# **North Lincolnshire Council**

**Application by RWE Renewables UK Solar and Storage Limited for Tween Bridge Solar Farm  
Project**

**North Lincolnshire Council's response to The Examining Authority's written questions and  
requests for information (ExQ1): Issued on 24 April 2026**

**Date: 19 May 2026**

Drawing Ref: Typical 100MW BESS Layout

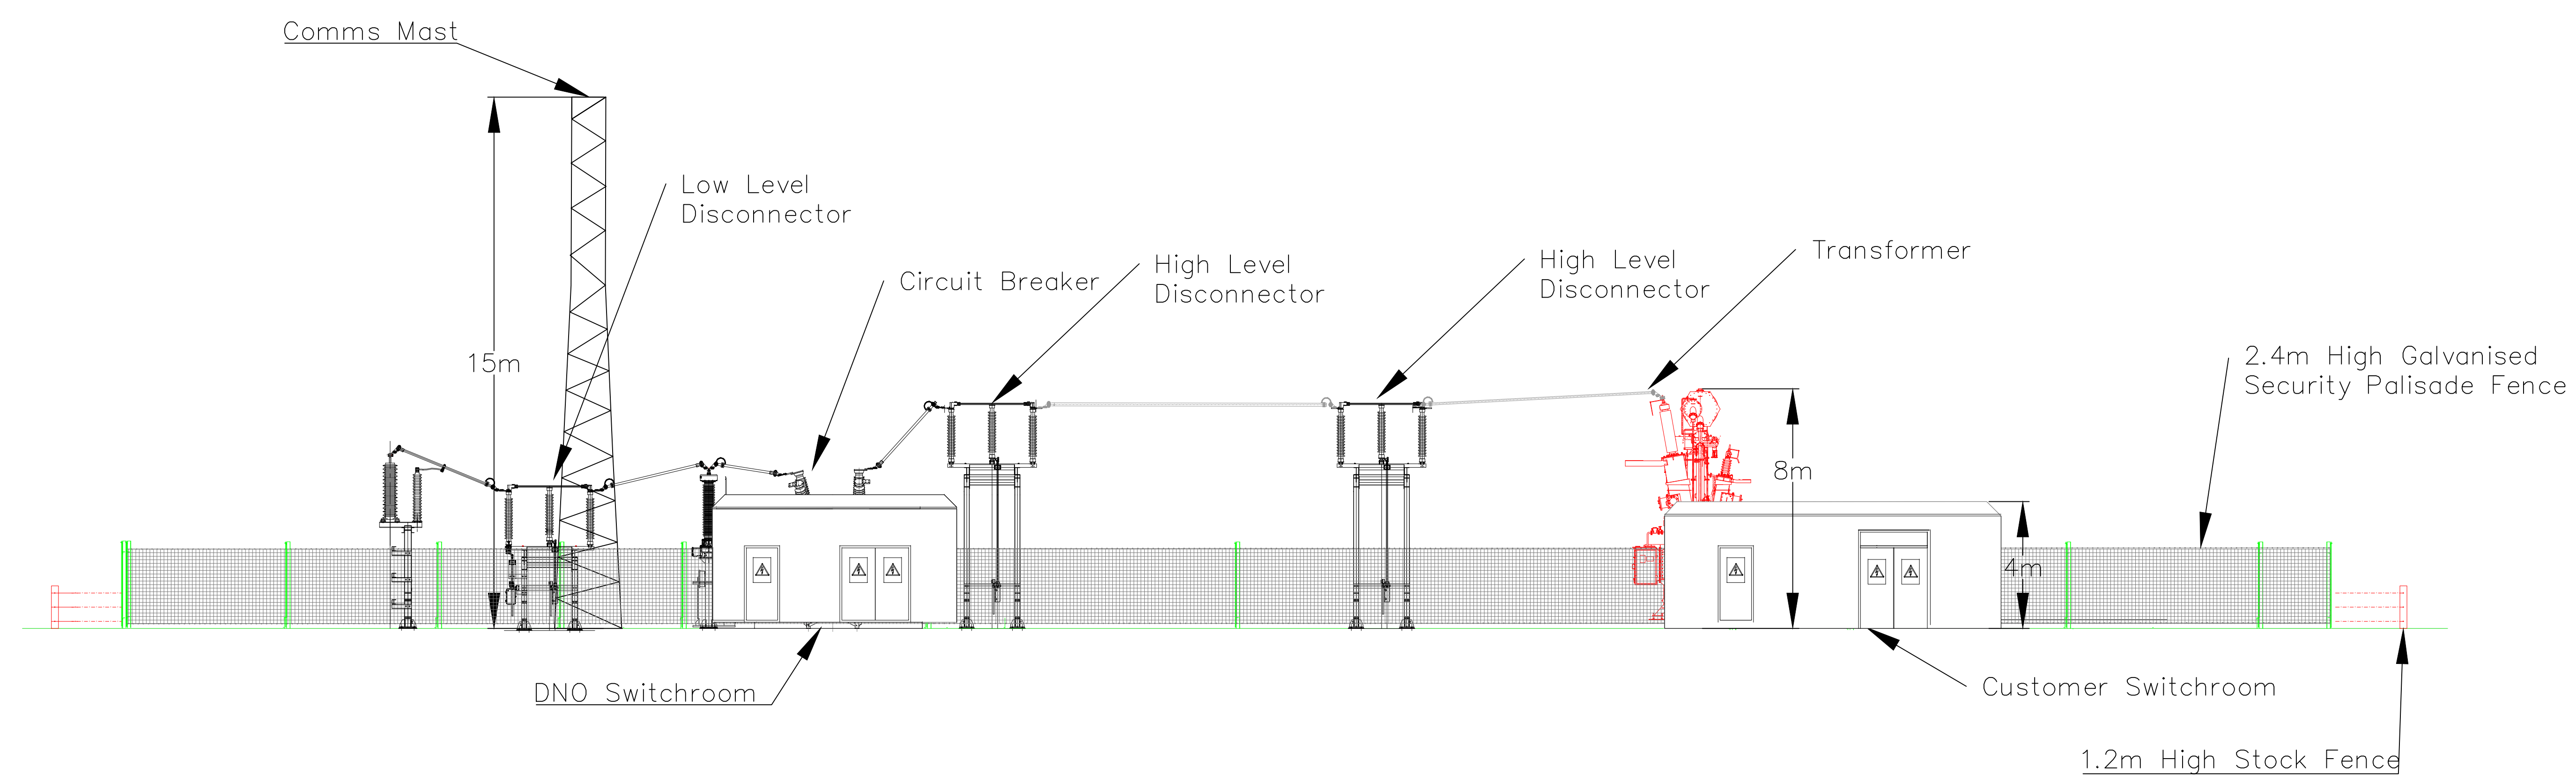
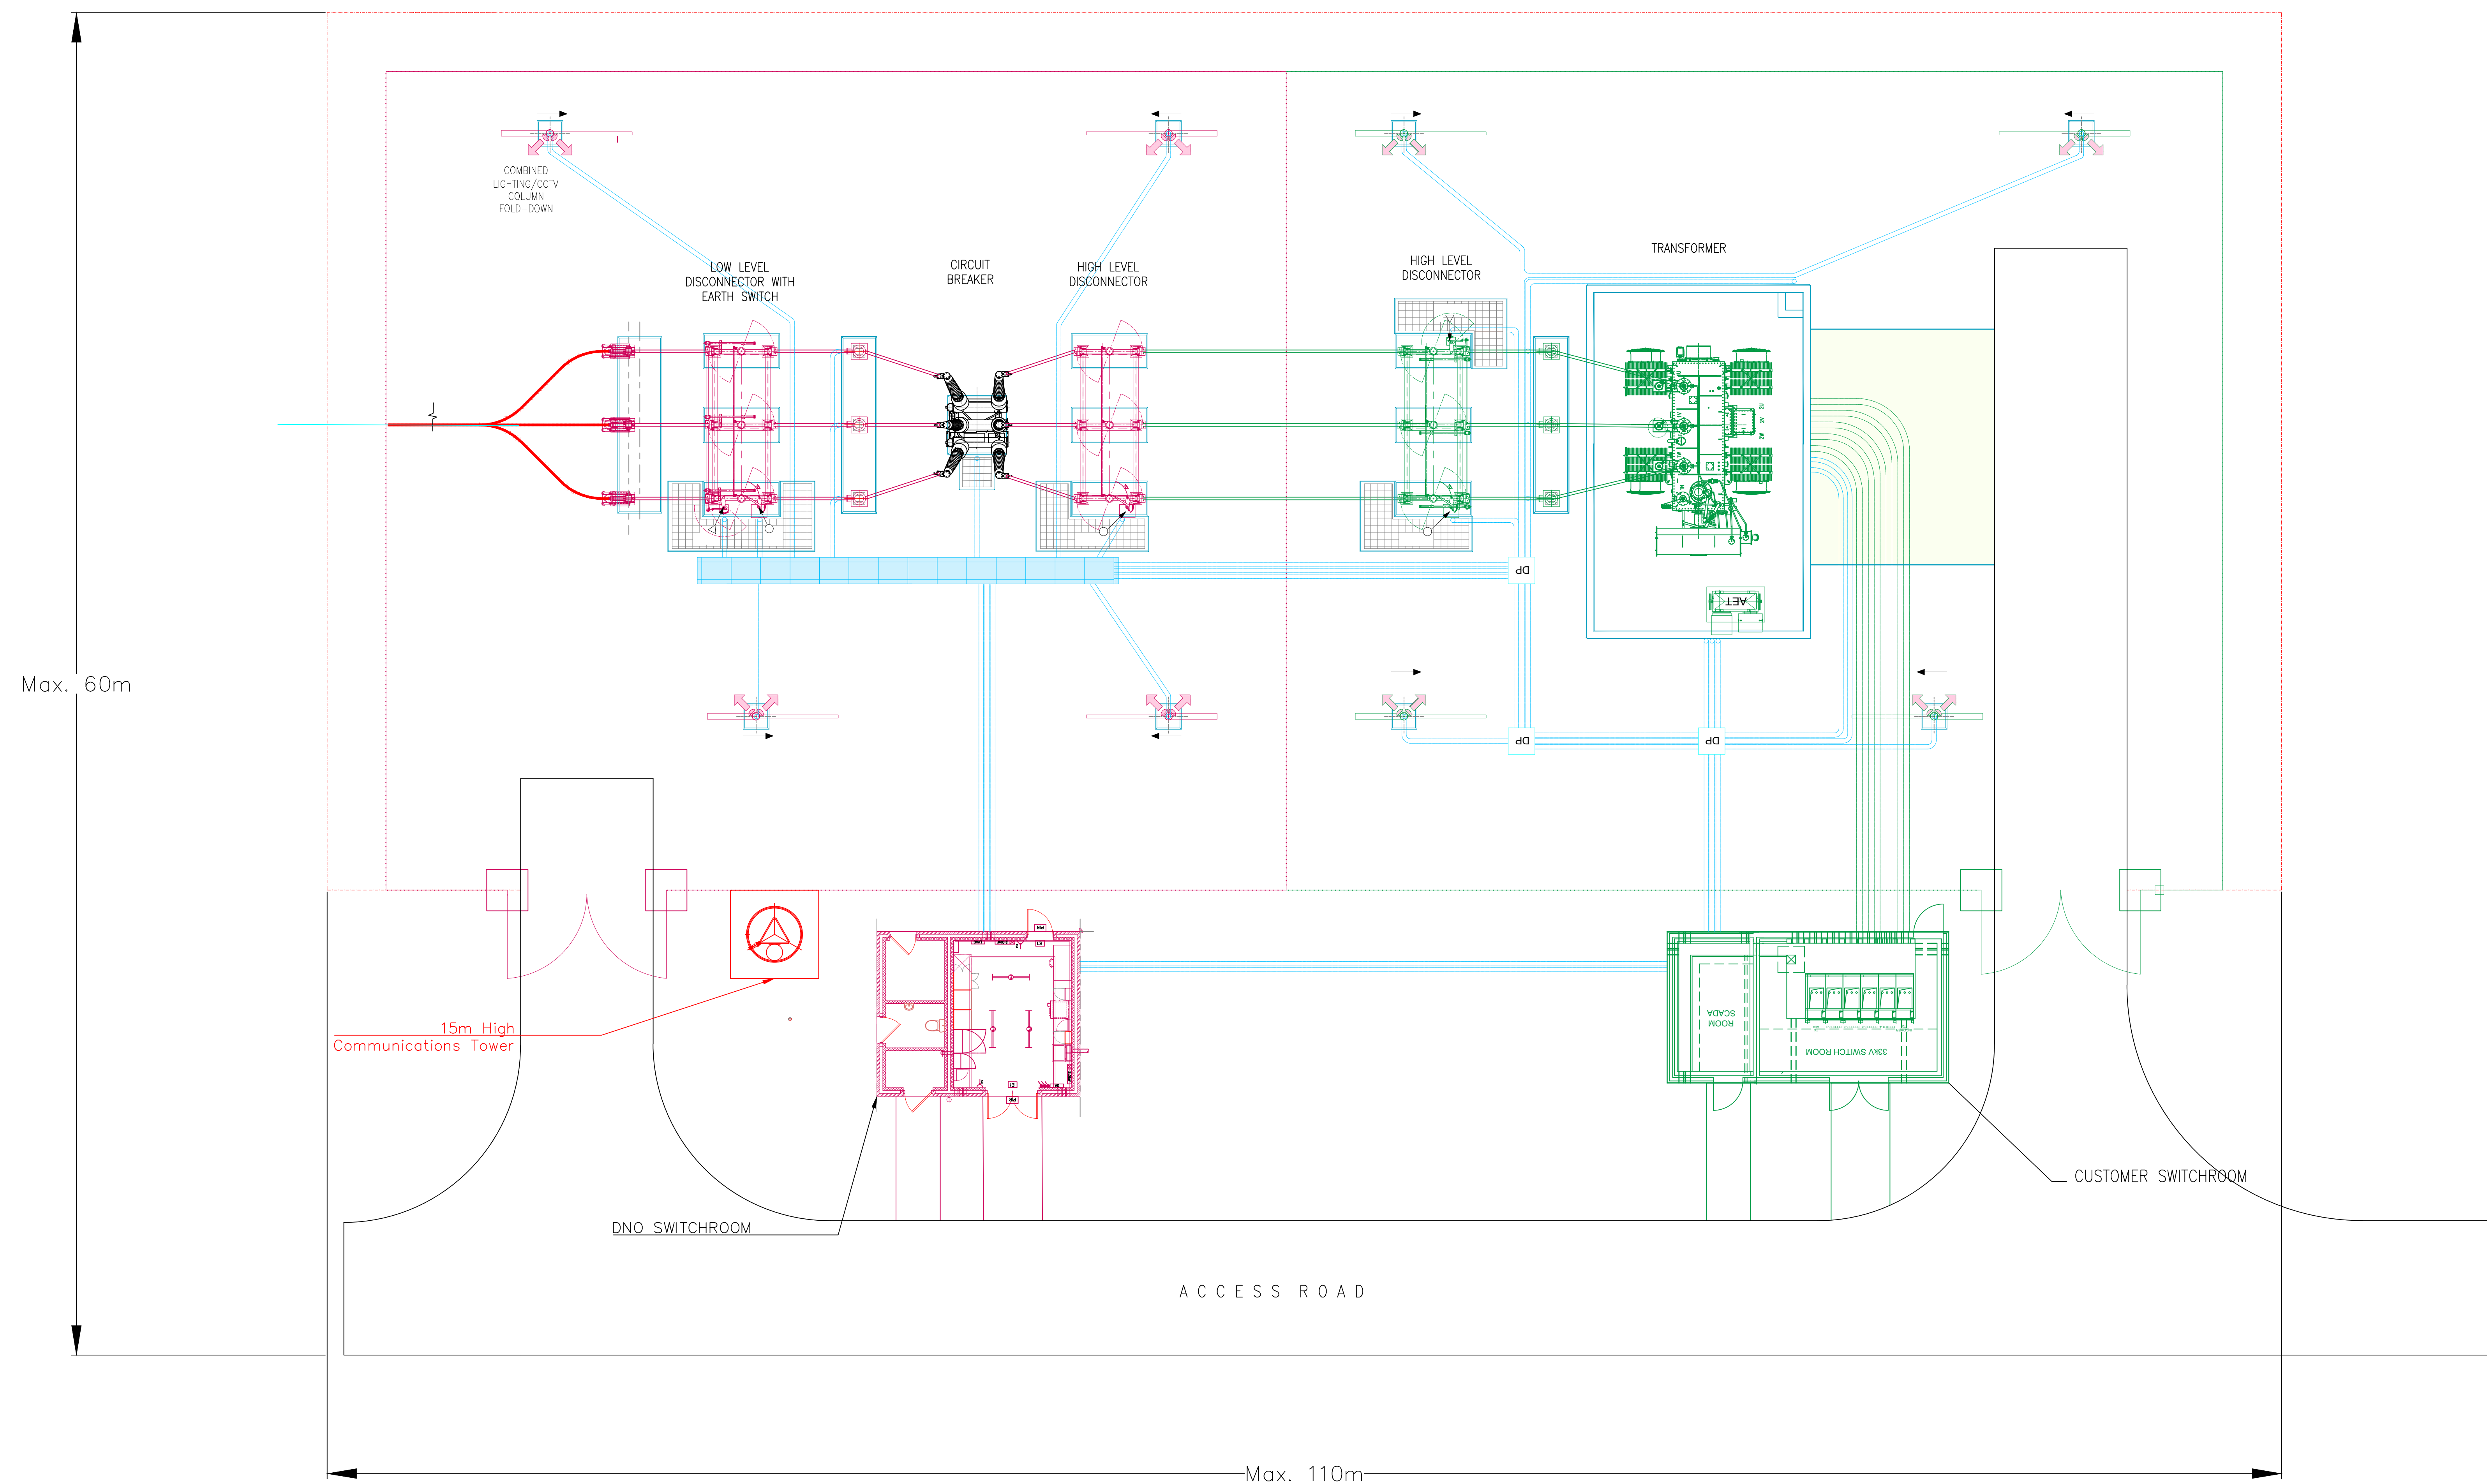
<p>NLC as Lead Local Flood Authority (LLFA) is supportive of the inclusion of firewater management measures such as shut-off valves, impermeable surfacing and containment, however these must be fully integrated into a system that prevents any uncontrolled discharge. The use of below-ground systems within both BESS and substation areas is not supported, given the need for accessible and maintainable infrastructure in high-risk environments. Above-ground attenuation, including lined basins or lagoons, should be prioritised as standard unless robust evidence demonstrates otherwise. This approach would better align with good SuDS practice and provide a more effective response to emergency scenarios.</p> <p>The pollution risks associated with BESS development are not limited to normal operation and must fully consider failure scenarios. Contaminants may include heavy metals such as lithium, cobalt and nickel, electrolyte compounds which can form highly toxic substances such as hydrofluoric acid, and per- and polyfluoroalkyl substances (PFAS) associated with firefighting foams, which are highly persistent and mobile in the environment. These substances present a high-consequence risk to both surface water and groundwater and are not readily managed through conventional drainage systems. NLC considers that the current approach underestimates this risk, and the drainage strategy should be revised to demonstrate robust containment, isolation and management of contaminated runoff in all scenarios.</p>
